Suffolk County Council (20041323)
Babergh and Mid Suffolk District Councils (20041302)

Local Impact Report: Annexes A to F
Bramford to Twinstead (EN020002)

Deadline 1

25 September 2023

2.11.1 Design and Layout Plans: Grid Supply Point Substation Layout [APP-019]

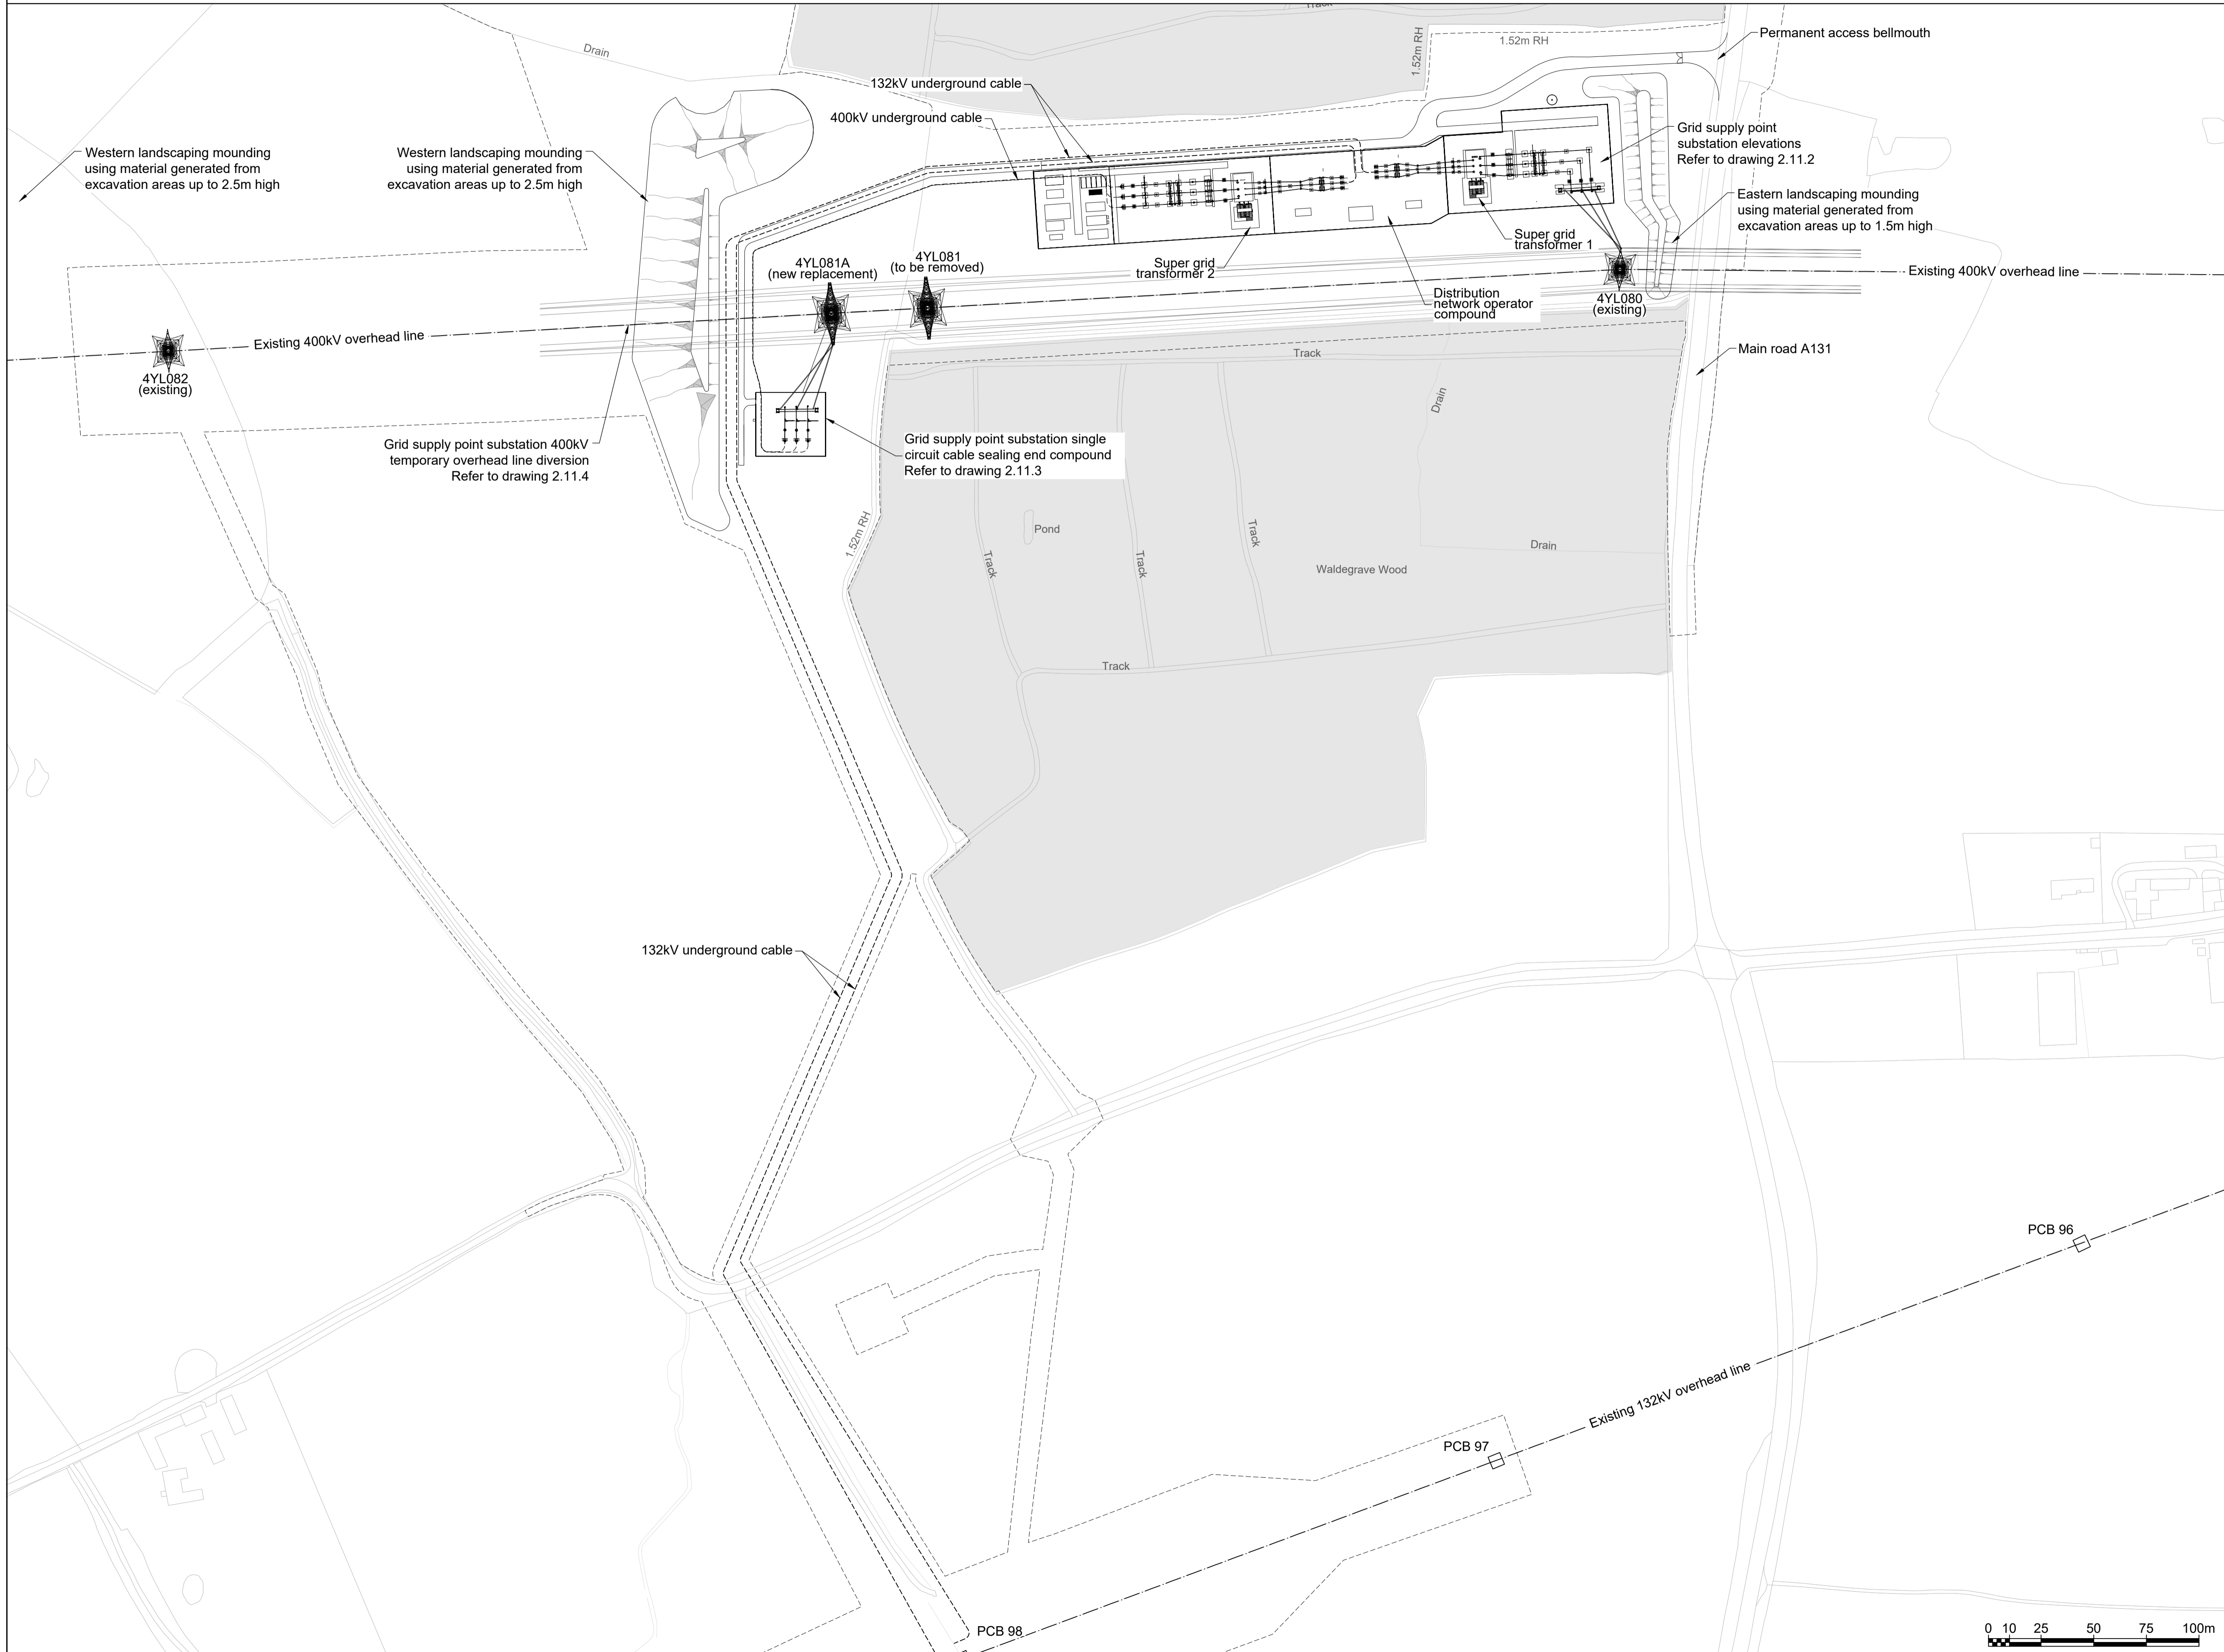
D.52 Shows an outline of an access at large scale but no details such as width, visibility, or construction materials are provided. Therefore, the LHA cannot comment on the feasibility, deliverability or acceptability of these proposals.
